MECKLENBURG COUNTY
Park and Recreation Department

MEMORANDUM

DATE: January 24, 2023

RE: Rezoning Petition #2022-078
PID# 06905104

SCHEMATIC SITE PLAN

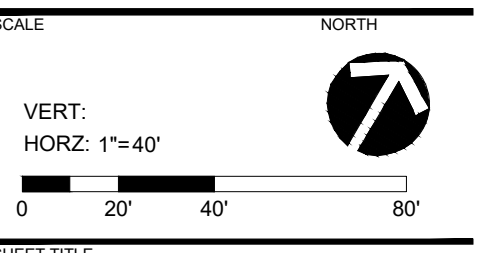
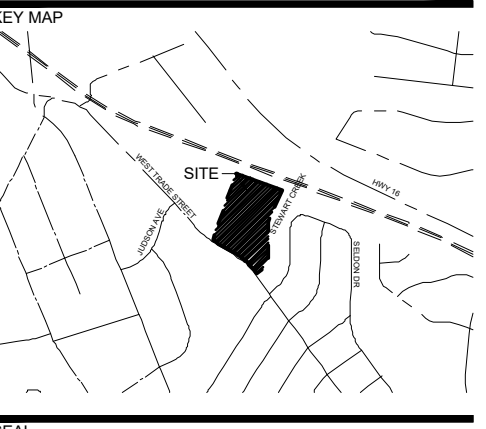
Plans currently show a 50' greenway easement along the entire property boundary. Per email communication with the petitioner, the dedicated greenway easement should be 100' wide except where the building is located within the SWIM buffer. Please revise the easement area to show the full 100' width for the remainder of the corridor. Also, include an easement that allows the trail to connect to the internal sidewalk network for access.
